**WELWYN HATFIELD BOROUGH COUNCIL
EXECUTIVE DIRECTOR - PLANNING, PUBLIC PROTECTION AND GOVERNANCE**

DELEGATED APPLICATION

Application No: 6/2018/0020/HOUSE
Location: 16 Daffodil Close Hatfield AL10 9FF
Proposal: Erection of a two storey rear extension and conversion of garage into a habitable room
Officer: Mr Richard Sakyi

Recommendation: Refused

PROPOSED FRONT ELEVATION

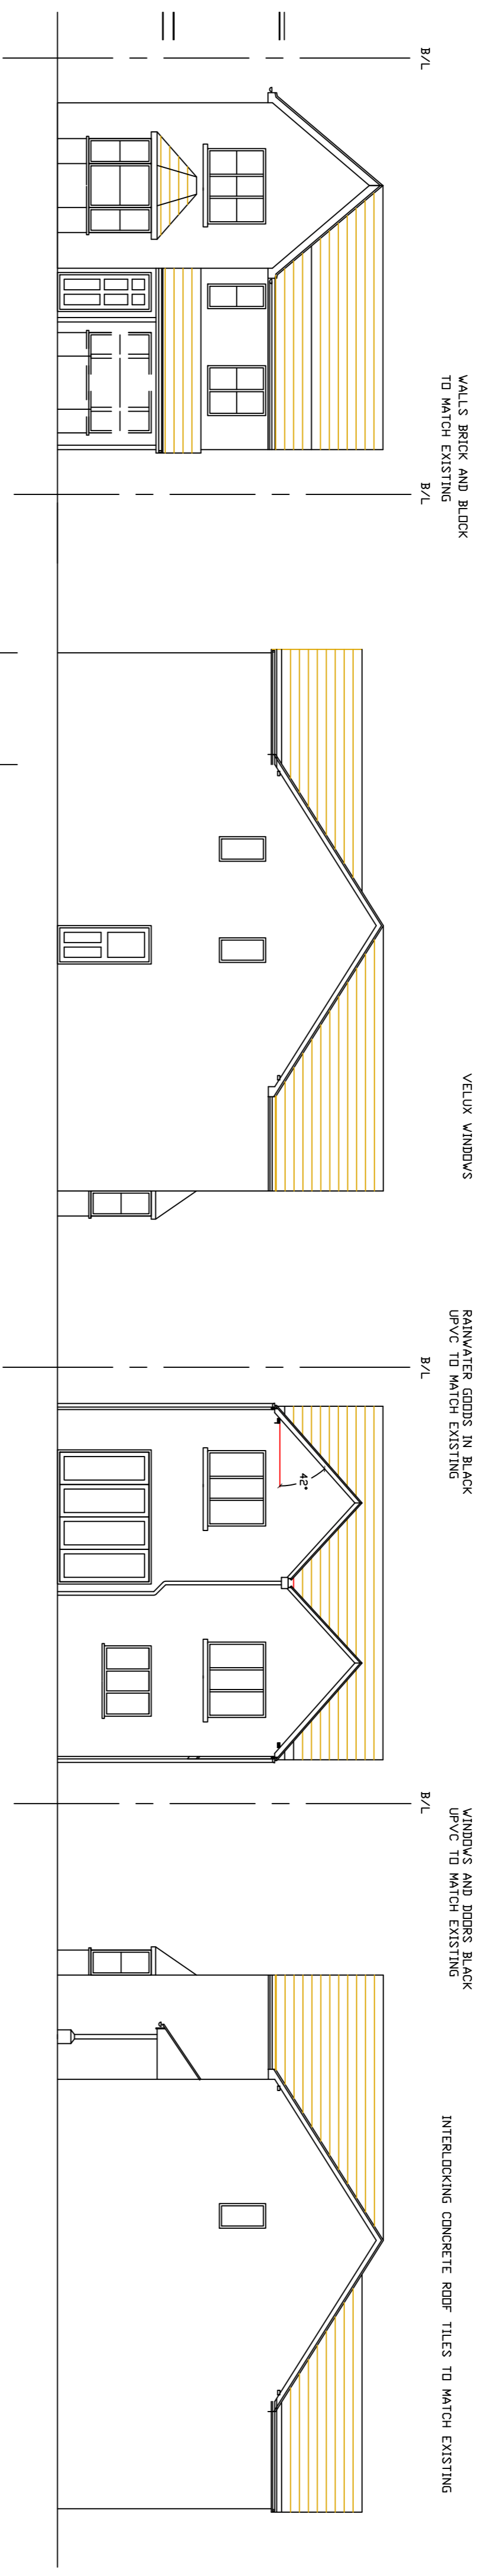
Comment (if applicable):	
Would the development reflect the character of the area?	
<input checked="" type="checkbox"/> Yes <input type="checkbox"/> No	
<p>Comment (if applicable): The conversion of the integral garage to habitable accommodation would involve the removal of the garage doors and the bricking up the space and the installation of window and materials, which would reflect those of the existing house.</p> <p>The proposed two-storey rear extension would have a depth of 2.5m and although would project beyond the established rear building line of the property and the adjoining houses however it is not considered that this would have any adverse impact on the character of the building and the area by virtue of its size and scale. Furthermore, the proposed rear extension would be constructed with matching external materials to reflect those of the existing and the adjoining properties. It is therefore considered that the proposed development would not have any significant adverse impact on the character of the area.</p>

PROPOSED GROUND FLOOR PLAN

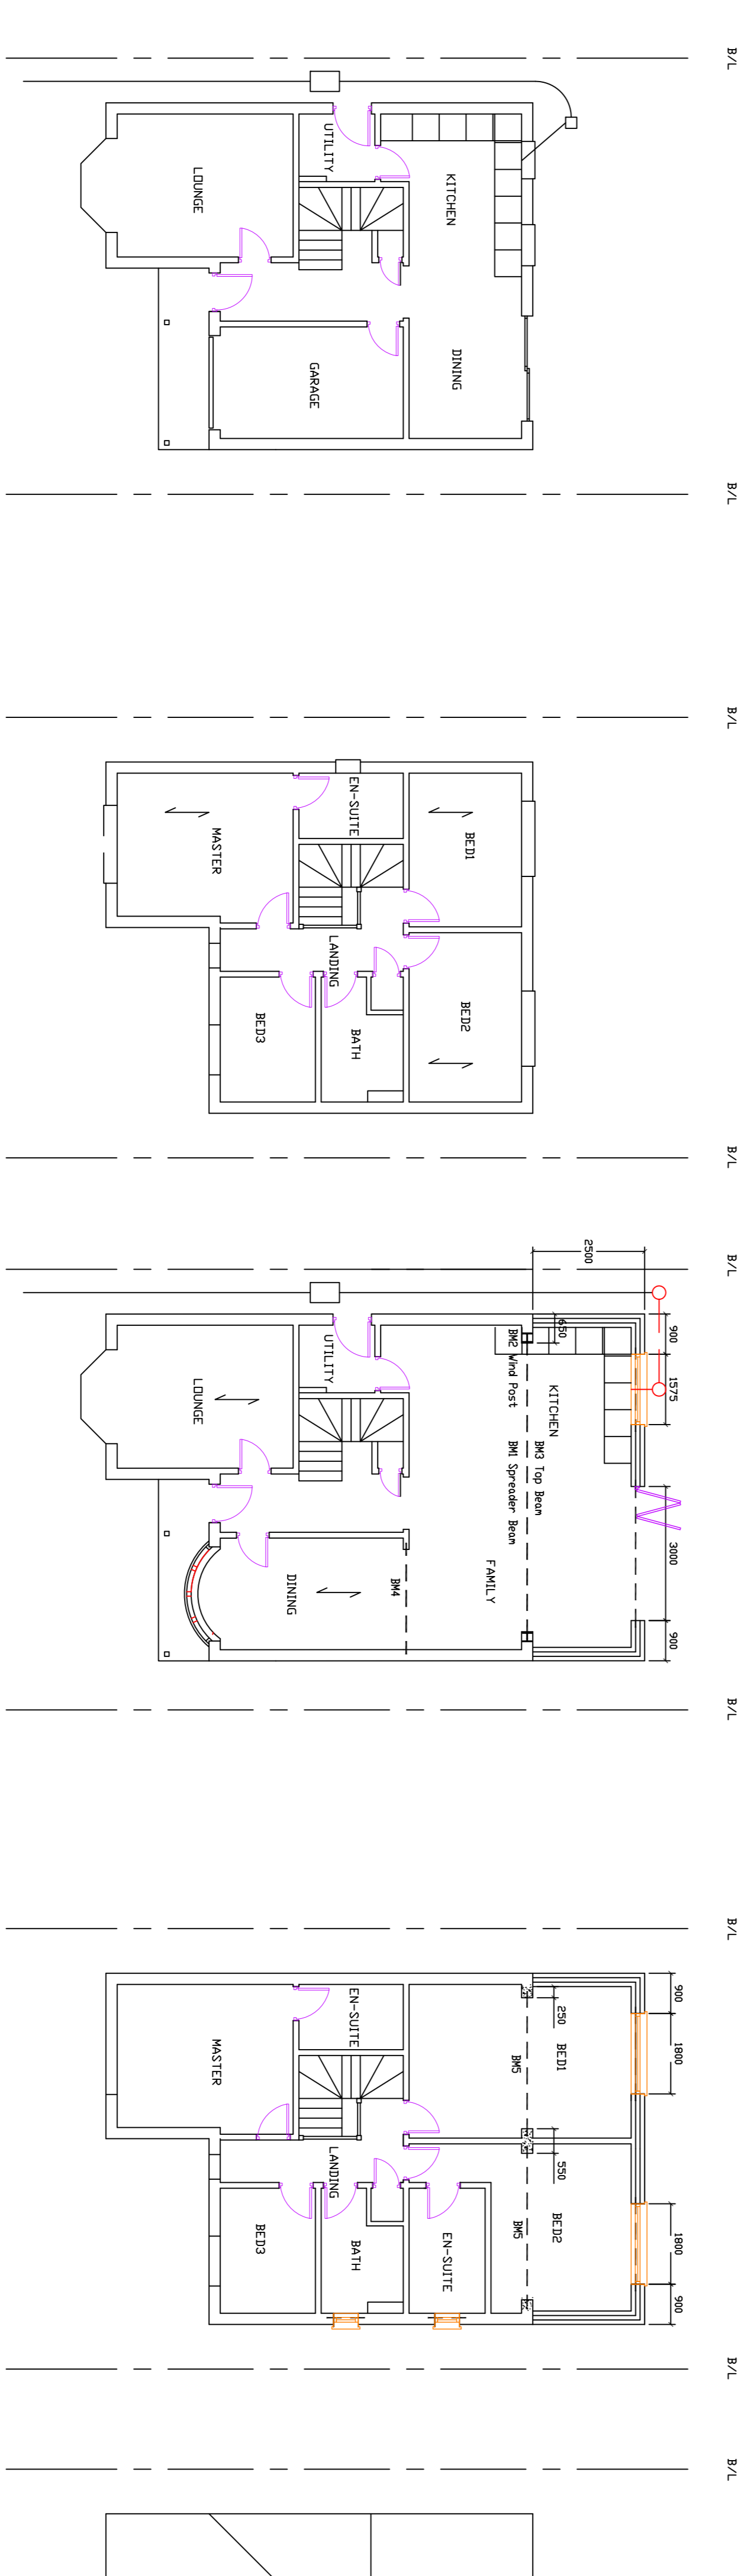
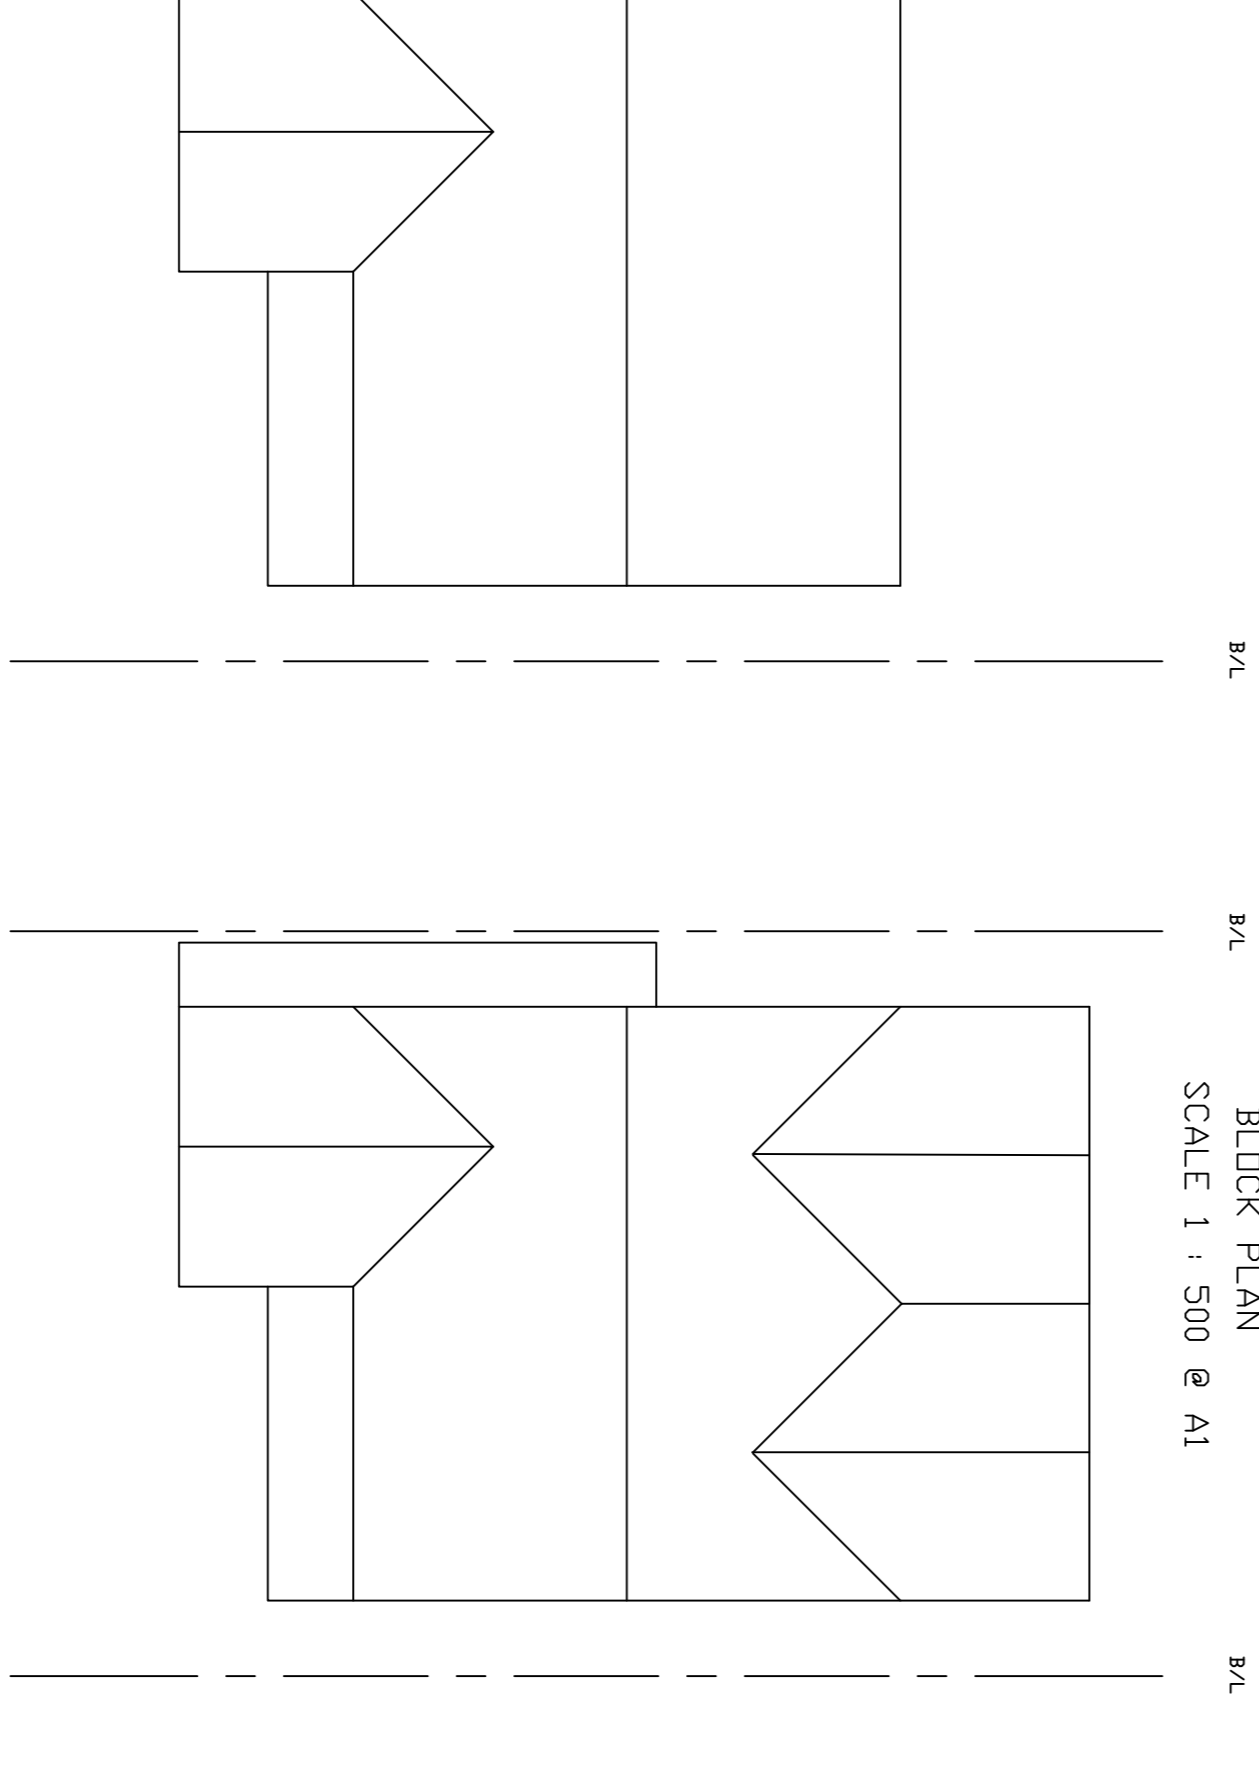
The dwellinghouse, as originally designed, has a provision of three car parking spaces - one single space within the garage and two parking spaces on the hardstanding in front of the garage which is an integral part of the design of this development. The proposed development would reduce the amount of parking spaces by one, retaining only two spaces for the four bedroom dwelling.

The loss of the use of the garage would not be compensated for by the provision of additional parking space within the site. This is because, the existing grassed area at the front appears to be inadequate by virtue of its limited width and therefore the imposition of a planning condition requiring the creation of additional space would be unreasonable and would not meet the test specified in the National Planning Policy Framework.

1. The proposal by virtue of the loss of the existing garage parking space would result in the loss of one off street parking space for the dwelling resulting in a deficit of parking for this dwelling. The proposal would increase the pressure for on road parking and would not be compatible with the maintenance and enhancement of the character of this residential development and accordingly fail to provide a high standard of design. Furthermore, the applicant has failed to demonstrate sufficient justification to the satisfaction of the Local Planning Authority that would outweigh this harm. The proposal is therefore contrary to the National Planning Policy Framework and saved Policies D1, D2 and M14 of the Welwyn Hatfield District Plan 2005 the Welwyn Hatfield District Plan, the Supplementary Planning Guidance for Parking Standards 2004 and the Council's Interim Policy for Car Parking Standards.
